CITY OF ALBUQUERQUE
PLANNING DEPARTMENT
LAND DEVELOPMENT COORDINATION DIVISION

4. Project # 1002318
02DRB-01649 Major-Bulk Land Variance
02DRB-01656 Minor-Prelim&Final Plat Approval

Re: Preliminary Plat – Tracts OS-2, OS-3 & Tract 13, High Desert
DRB Project # 1002318; 02DRB-01649 Major-Bulk Land Variance; 02DRB-01656 Minor-Preliminary &
Final Plat Approval

DEVELOPMENT REVIEW BOARD
November 20, 2002
Project # 1002318

BULK LAND PRELIMINARY PLAT
FOR TRACTS 13A, 13B, 13C, OS-2A & OS-3A
A REPLAT OF TRACTS 13, OS-2 & OS3
AT HIGH DESERT
 ALBUQUERQUE, NEW MEXICO
 OCTOBER, 2002

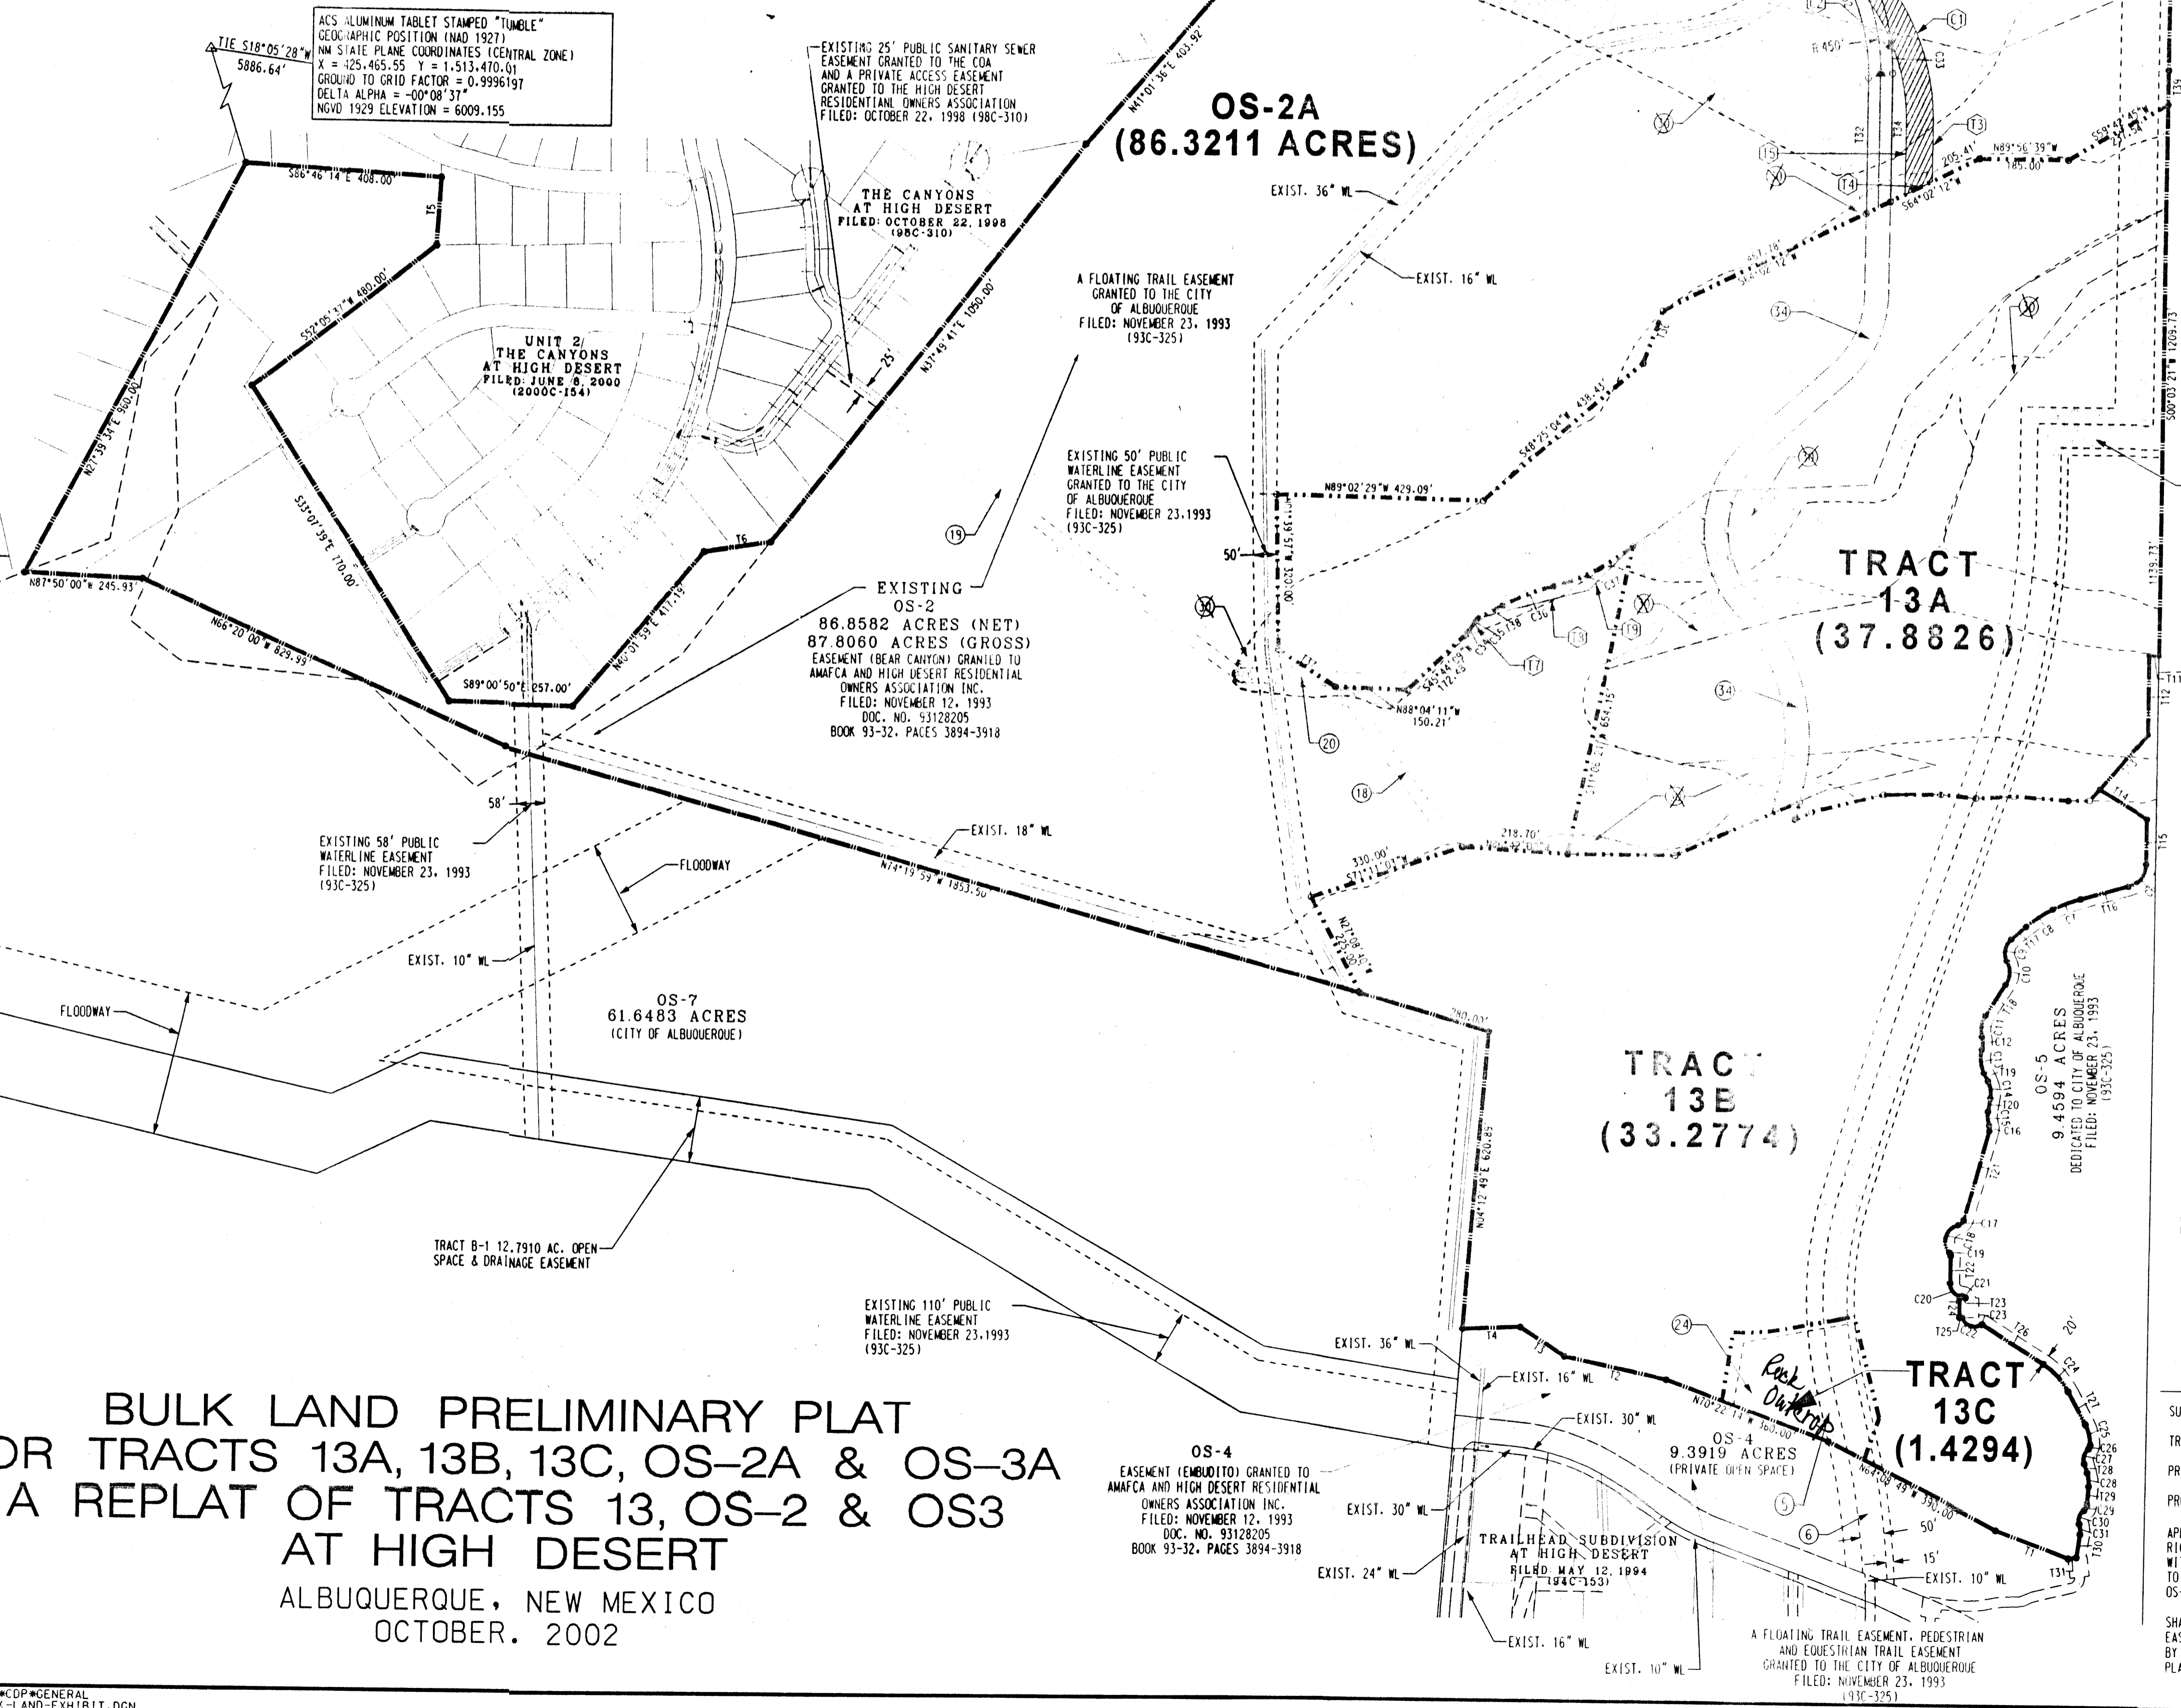
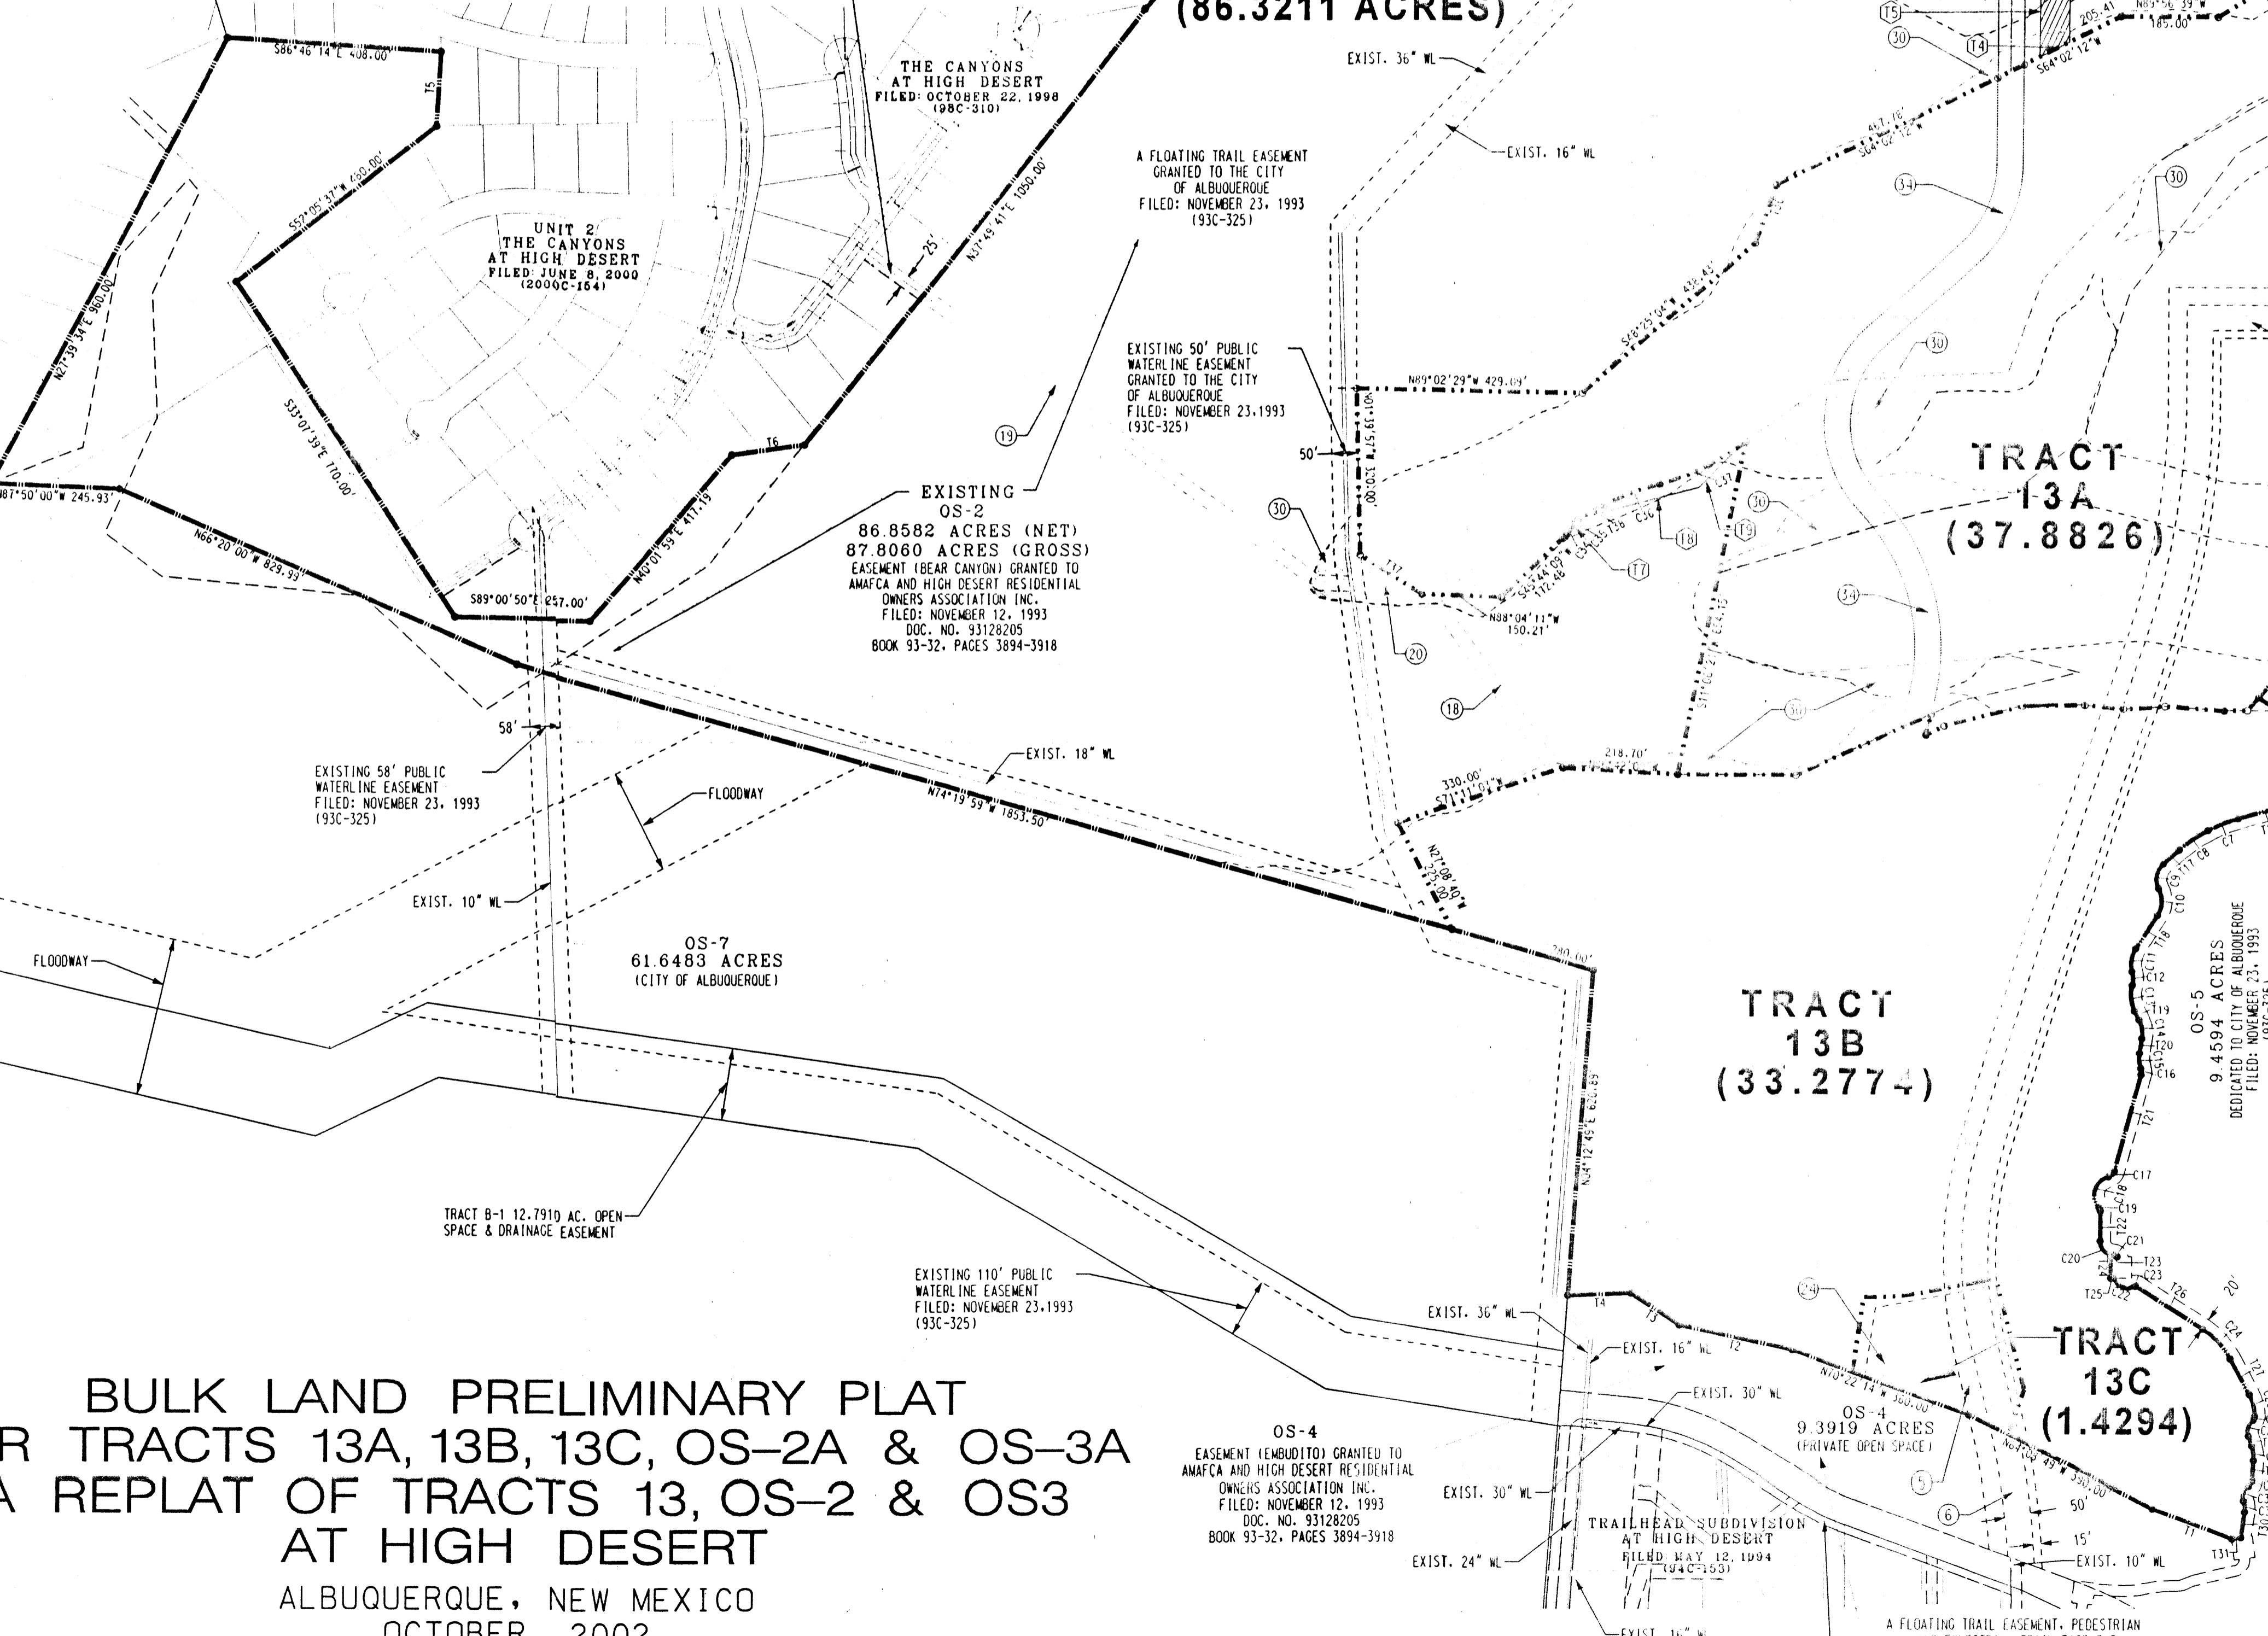
The preliminary plat has been revised to remove note 30 which references the vacation of the existing AMAFCA easements. The AMAFCA easements indicated in note 30 will be vacated with the subdivision platting action for Units 1, 2 and 3 of the Wilderness Subdivision at High Desert. The preliminary plat for Units 1, 2 and 3 of the Wilderness Subdivision at High Desert is also being heard at DRB on Wednesday, November 20, 2002 (DRB Project # 1002315). The remaining vacations (public right-of-way, public waterline and desilting basin easements) will be vacated and shown on the "Bulk Land" Plat.

The planning department indicated that Map 11 in the High Desert Sector Plan shows a pedestrian trail within the boundaries of the bulk land variance and that the bulk land exhibit submitted does not clearly indicate where this trail would be located. The trail location is not required to be shown or located with the bulk land plat but instead has been shown on the preliminary plat for the Subdivision (DRB Project # 1002315). A trail will be located along the east side of the High Desert Place as is indicated on the infrastructure list. Planning also indicated that the legend did not clearly show the difference between property line and proposed right-of-way line. The legend along with the existing notes provided on the enclosed revised "Bulk Land" preliminary plat help identify the right-of-way lines and property lines.

1. Map 11 in the High Desert Sector Plan shows a pedestrian trail within the boundaries of the bulk land variance. The bulk land variance exhibit submitted does not clearly indicate where this trail would be.
2. The legend does not clearly show the difference between a proposed property line & a proposed right of way line. There are many similar lines on the exhibit.
